# ***City of Albuquerque***

**Re: Rio Vista Church, 8701 Golf Course Rd NW, Grading and Drainage Plan  
Engineer's Stamp dated 4-26-04 (C12/D2E)**

**Re: Rio Vista Church, 8701 Golf Course Rd NW, Site Development Plan  
Engineer's Stamp dated 3-09-04 (C12/D2E)**

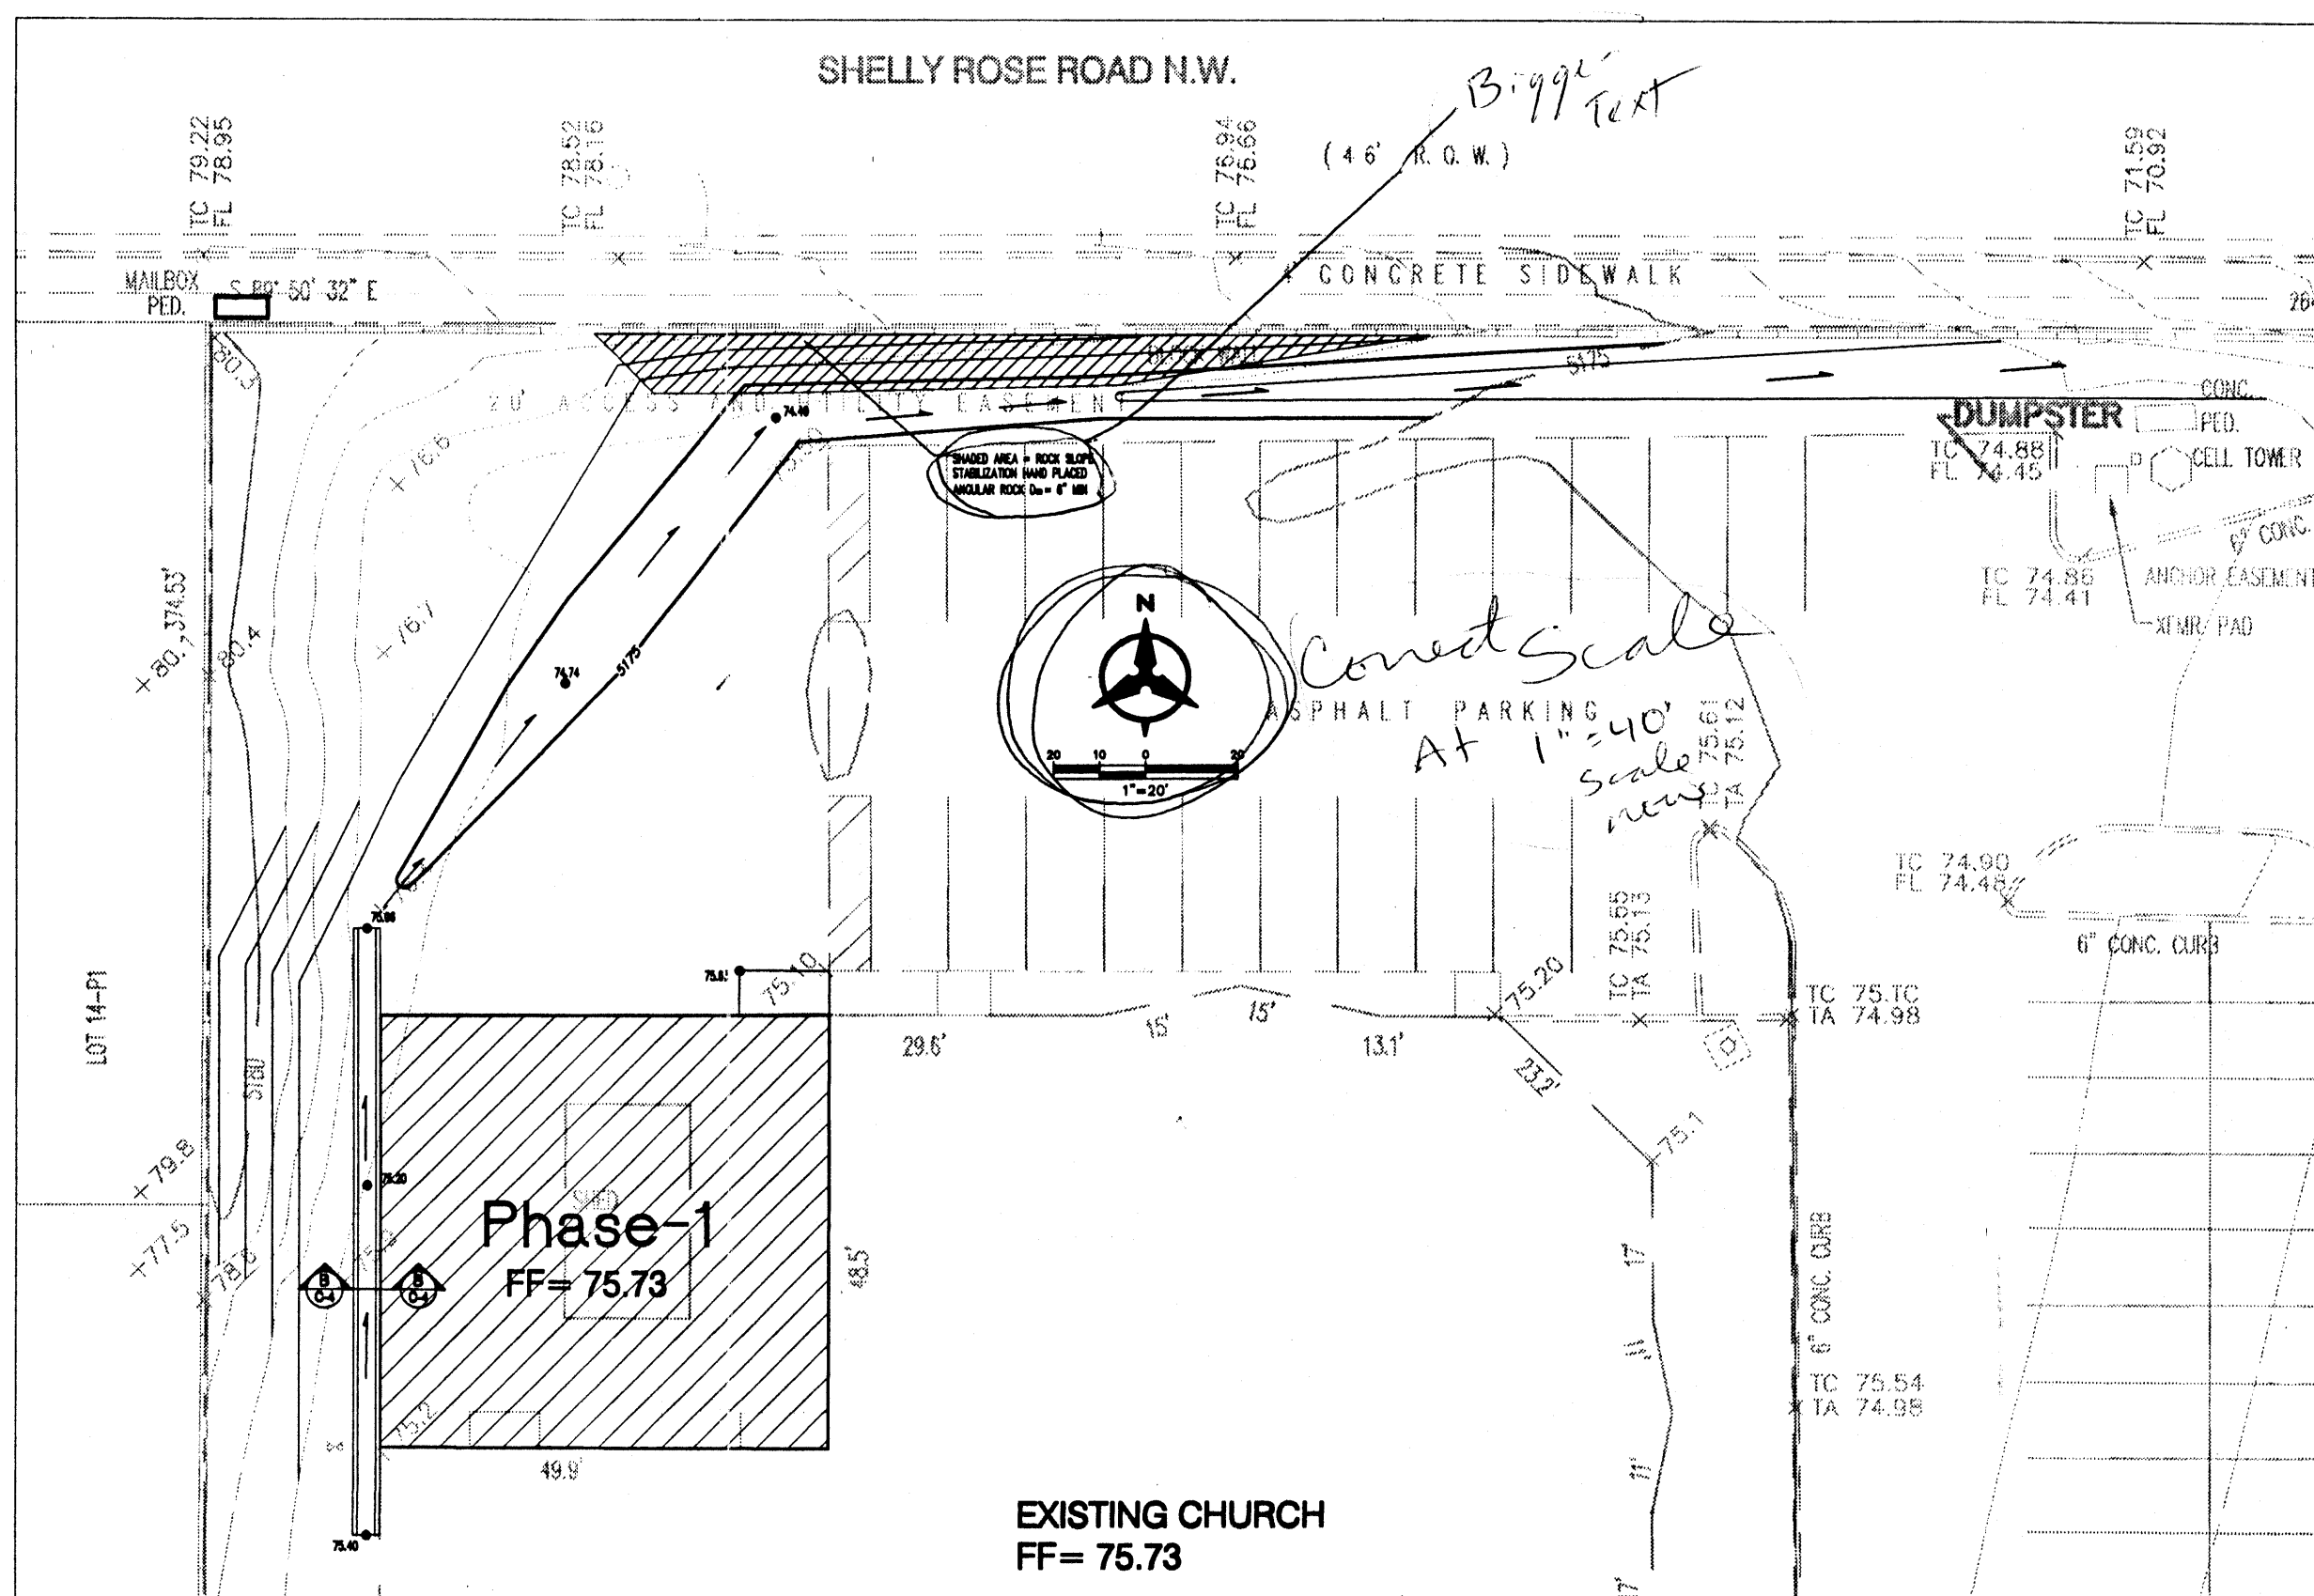
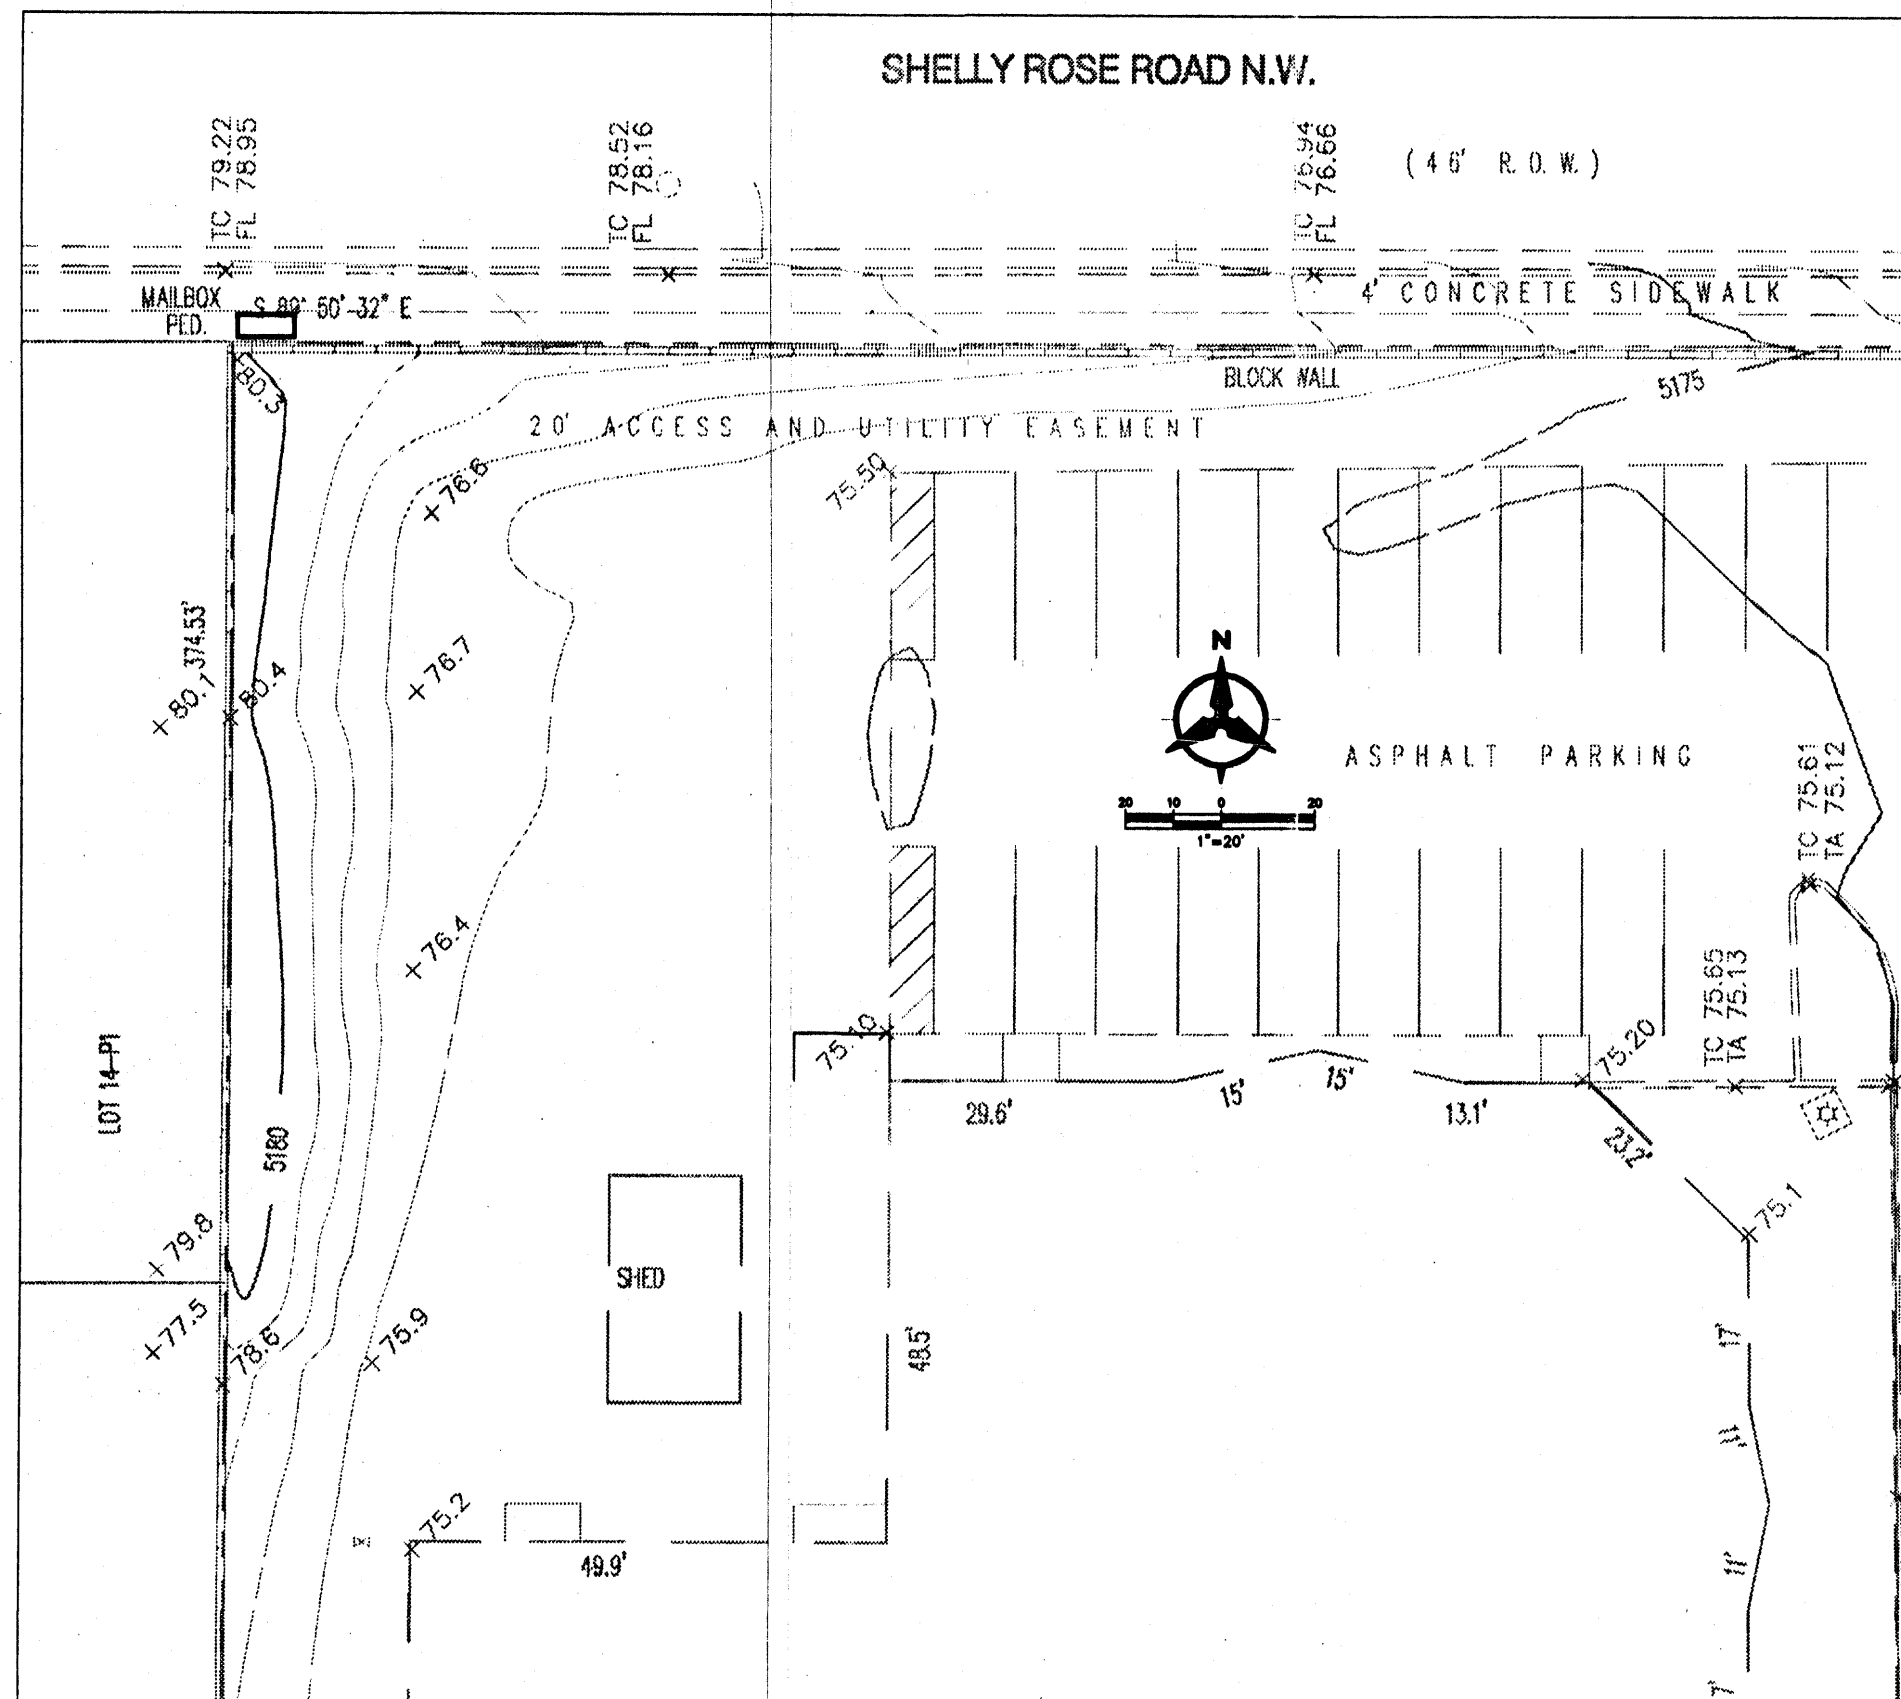
1. Provide an executive summary.
2. Please address offsite flow, if any exists.
3. Is this site located in a flood plain?
4. Provide a more detailed view of the proposed drainage structures, keeping in mind that a maximum of 12" storm drain is allowed per City Standards.
5. Show the drainage calculations and runoff quantities.
6. Please provide a benchmark.

- An executive summary is provided;
- There are no offsite flows impacting this site. This is shown in the executive summary;
- A drainage table is provided showing the existing and proposed drainage calculations;
- The Federal Emergency Management Agency Map is referenced in the executive summary stating the there is not a flood plain/zone within proximity to the site.
- There <sup>are</sup> ~~is~~ no proposed drainage structures planned for the construction of this phase so no structures will be shown.
- A benchmark is shown under the vicinity map on the upper right hand corner of the sheet.
